Re: Planning Application 20/0845

Address: Stonyhurst College Avenue Road Hurst Green BB7 9PZ

Description: Construction of a single storey rugby pavilion, covered spectator areas, an enclosed space for pitch side medical facilities, light refreshments and storage. Pavilion to be of vernacular form, with an exposed oak framed construction and a pitched tiled roof. Pavilion to be centred along the North West boundary of the First 15 college rugby pitch known as Smith Field.

- Construction Traffic Route to Pavilion**
 The route to the pavilion during construction will be along the existing driveway and track through the tree belt. A review of the suitability of this track for construction traffic is required.

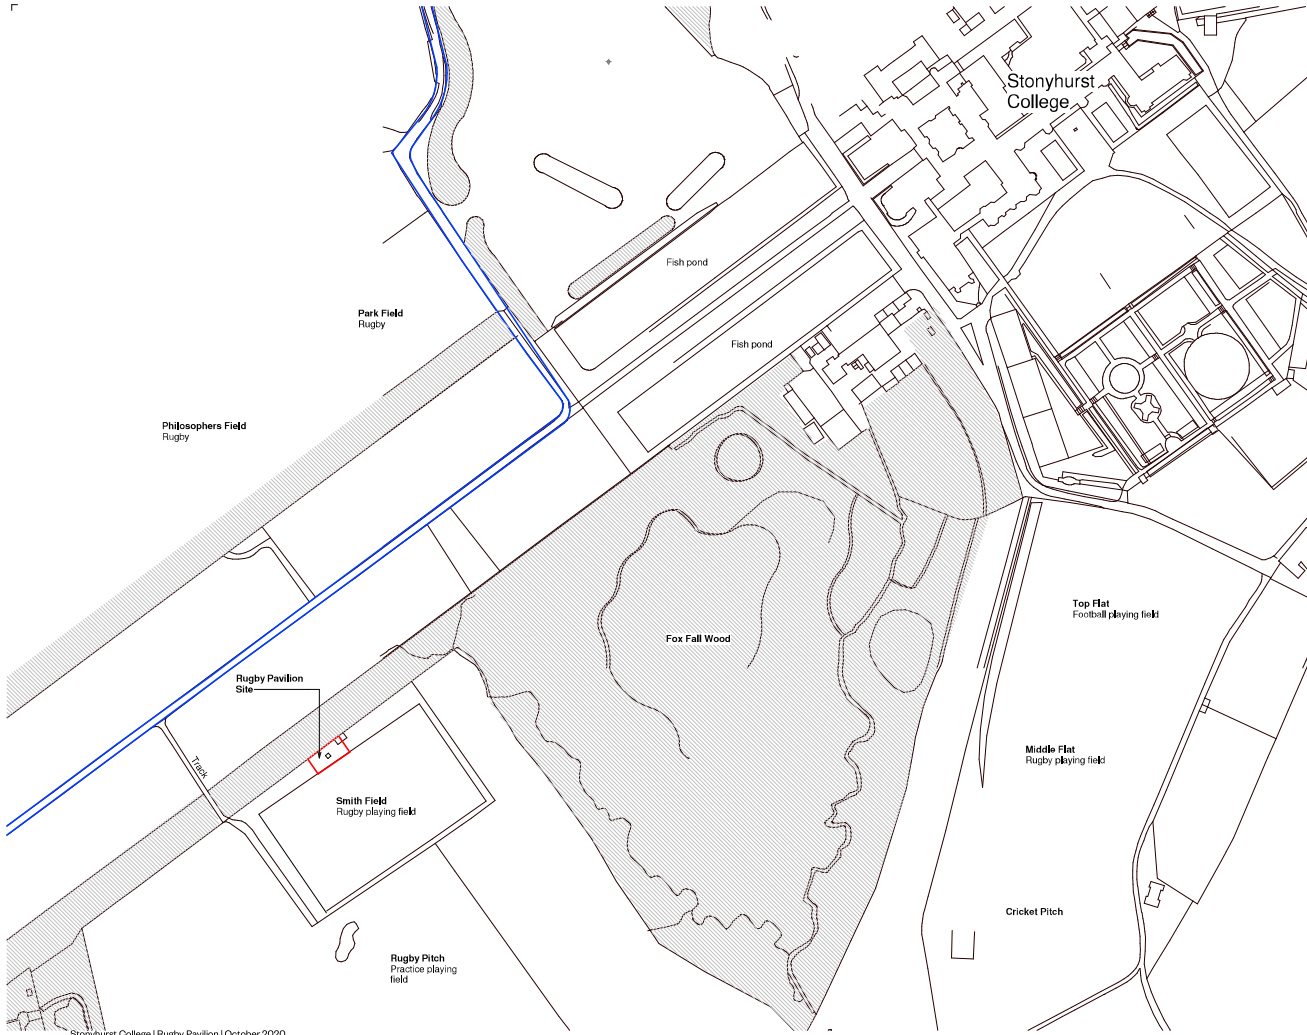
There is however a concern regarding the junction of the access track and Avenue Road. It is expected that there will be a number of large and heavier vehicles using this track and there is a concern that the highway structure may be damaged at the join of the two surfaces.

It is recommended that the first 5m of the track is improved with a bound surface, and widened to allow for the swept path of a 26 tonne 10m 3 axle Heavy Goods delivery vehicle to access the building site.

1. Before the access is used for vehicular purposes, that part of the access extending from the highway boundary for a minimum distance of 5m into the site shall be appropriately paved in tarmacadam, concrete, block pavements, or other approved materials. **Reasons:** To prevent loose surface material from being carried on to the public highway thus causing a potential source of danger to other road users.
